July 27, 2022

Re: SAIA – *Technical Review 1*
PA 22025

SUBJECT: PA22-025 SAIA Marysville
NE corner of State Avenue and 128th Street NE
APN: 30050400300200

SHEET NUMBER
C4.0

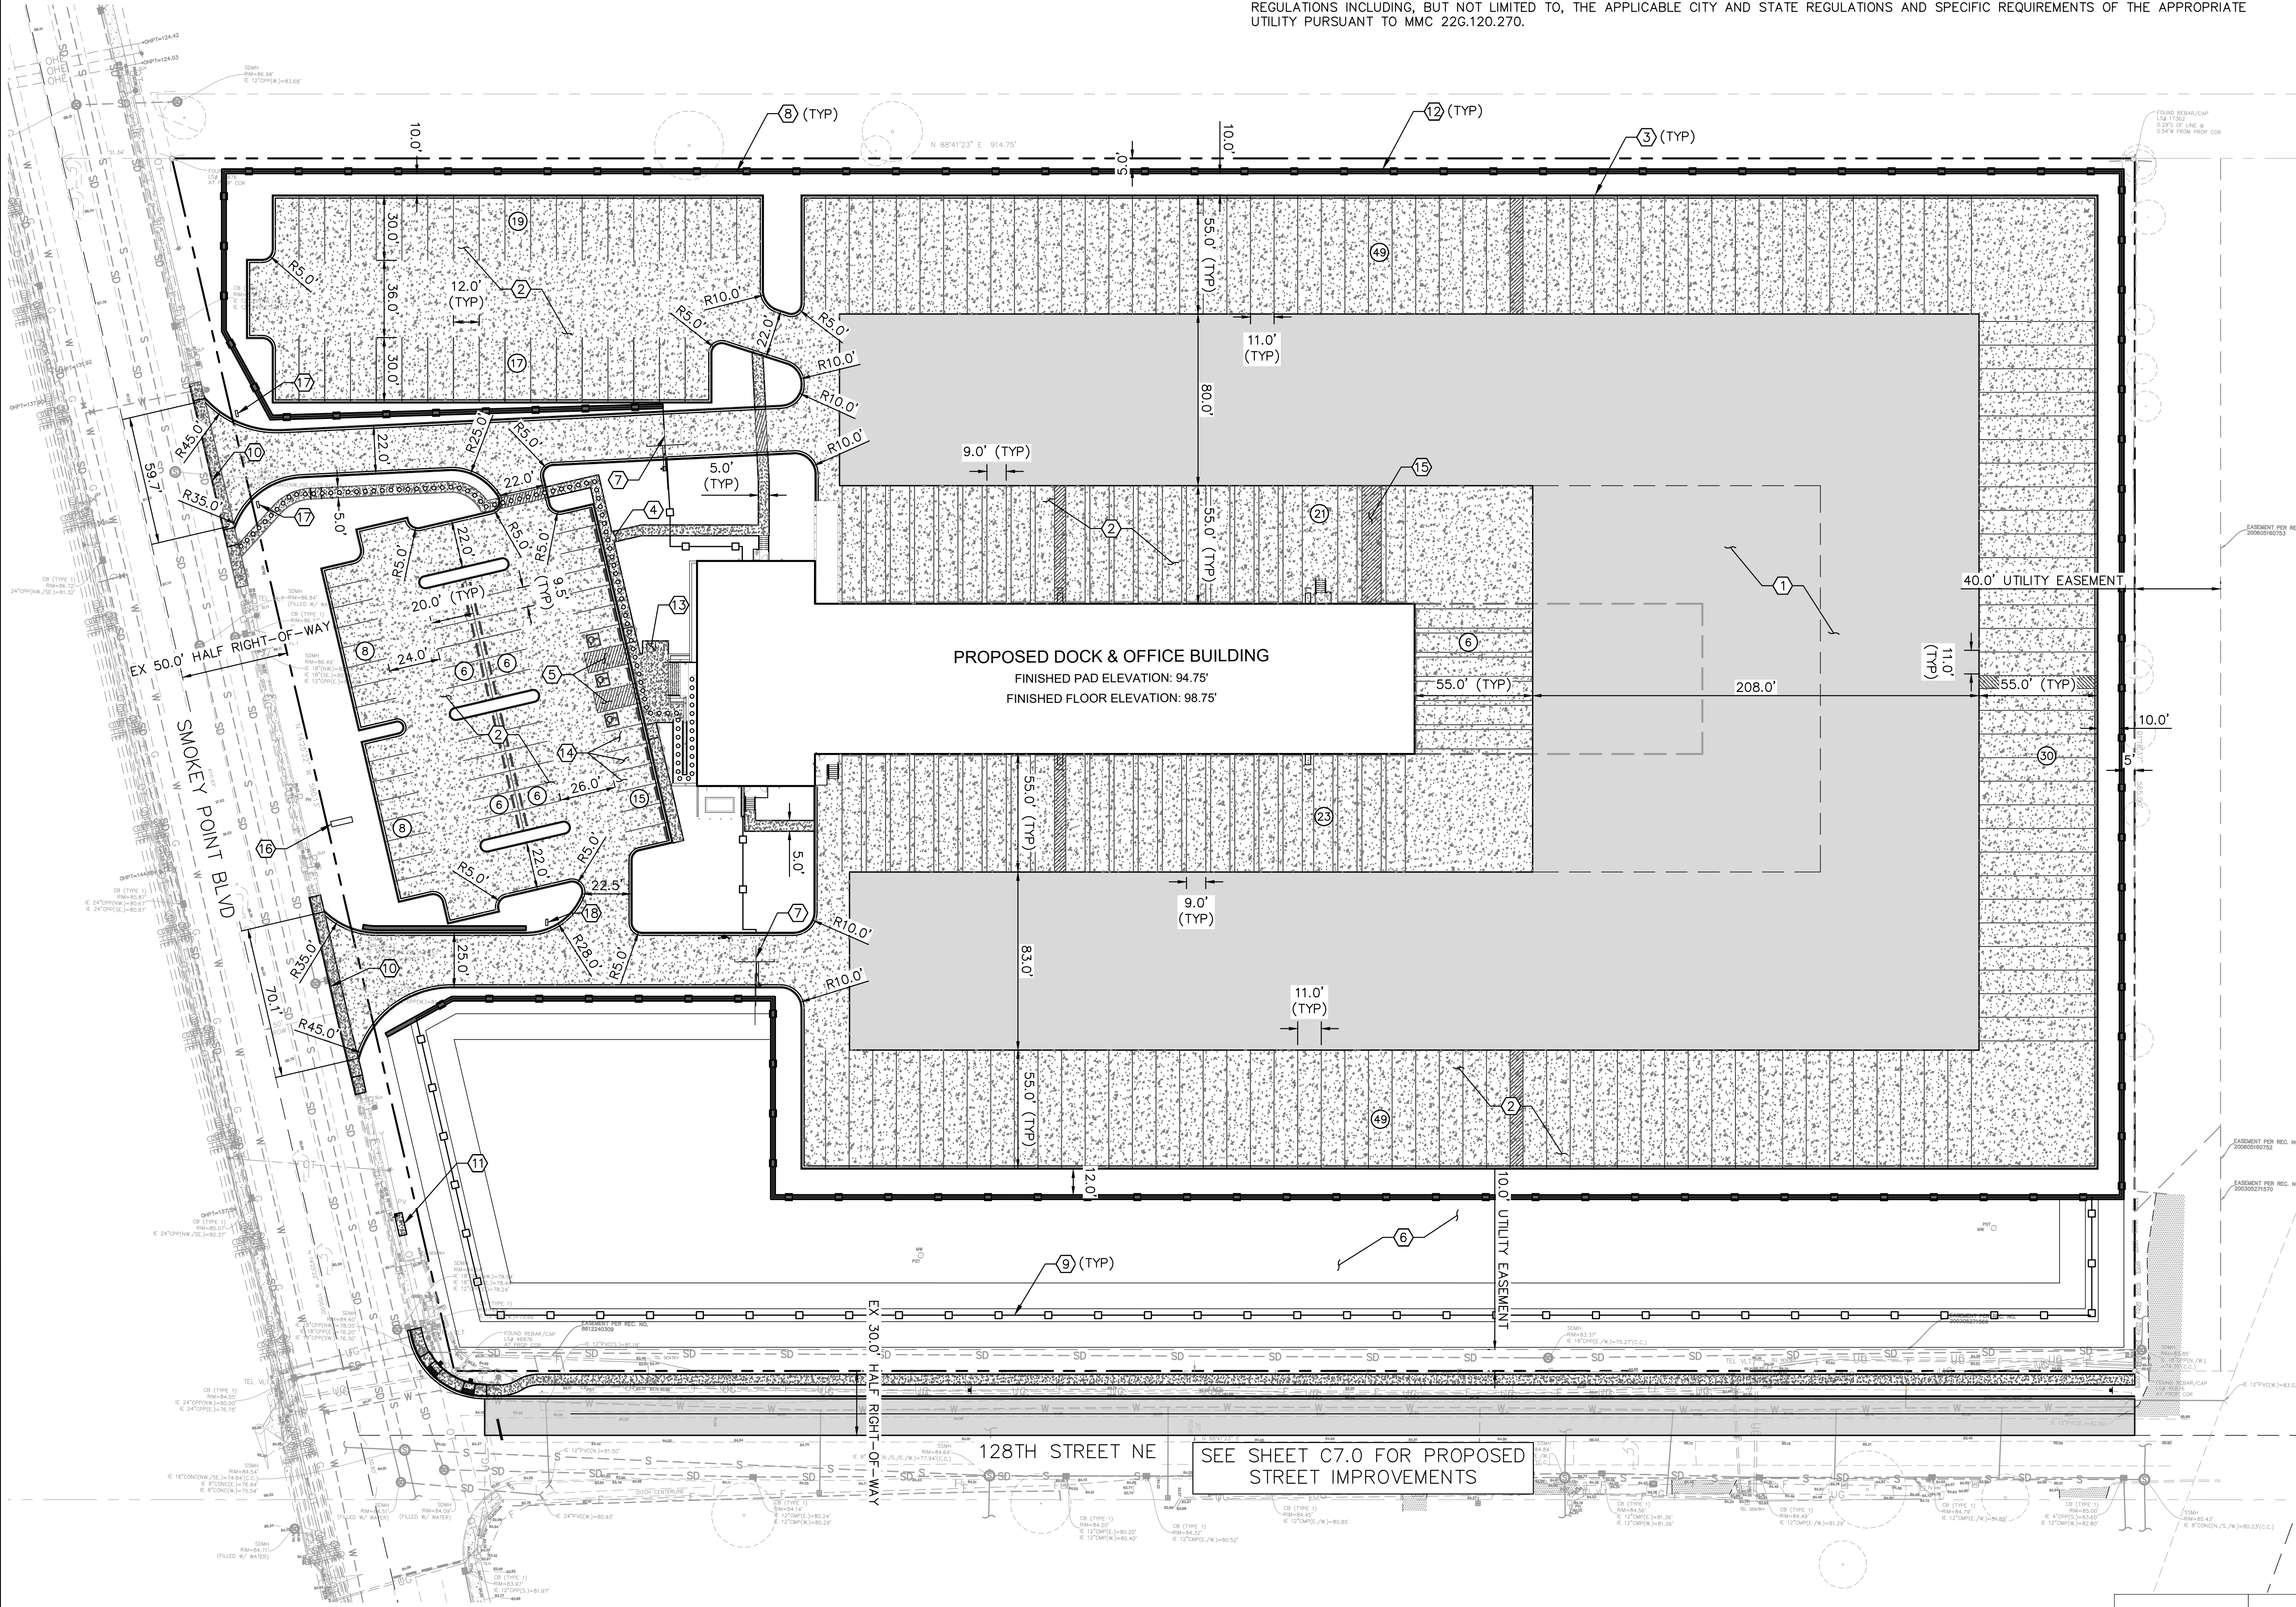
3. The attached Snohomish County Traffic Offer will need to be signed by the applicant and returned to City.
4. Amend Sheet C4.0 as follows (see attached redlines):

- a. Provide bulk & dimensional calculations outlined in [MMC 22C.020.080](#)(2) for the LI zone.
 - b. Provide required parking calculations outlined in [MMC 22C.130.030](#) Table 1.

- . Office - 1 per 400 SF GFA
 - c. Provide carpool parking locations and calculations in accordance with [MMC 22C.130.030](#)(3).
 - d. Provide required bicycle parking calculations outlined in [MMC 22C.130.060](#).

- e. The minimum drive-aisle width on the northern entry way, access to the employee parking area and within the employee parking area shall be 22'.
 - f. Move the pedestrian pathway 5' south of the north drive-aisle and provide street trees and sod between the curb and pathway.

- g. Pedestrian pathways that traverse a drive aisle are required to be constructed with decorative concrete clearly denoting the pedestrian pathway. The pathways

- i. Provide details of the proposed security gates, security fencing, retaining wall fencing and detention bond fencing.
- j. Retaining walls shall be designed in accordance with [MMC 22D.050.030](#) (4). If retaining walls taller than four feet are used, as measured from the average grade, and are visible from the street or adjacent property, they shall be terraced so that no individual segment is taller than four feet; provided, that where adjacent properties are not adversely affected or the retaining wall is minor in nature, the community development director may reduce or waive these standards. Terraced walls shall be separated by a landscaping bed at least two feet in width. Alternative landscaping treatments will be considered, provided they reduce the bulk and scale of the retaining wall and enhance the streetscape or transition between properties.
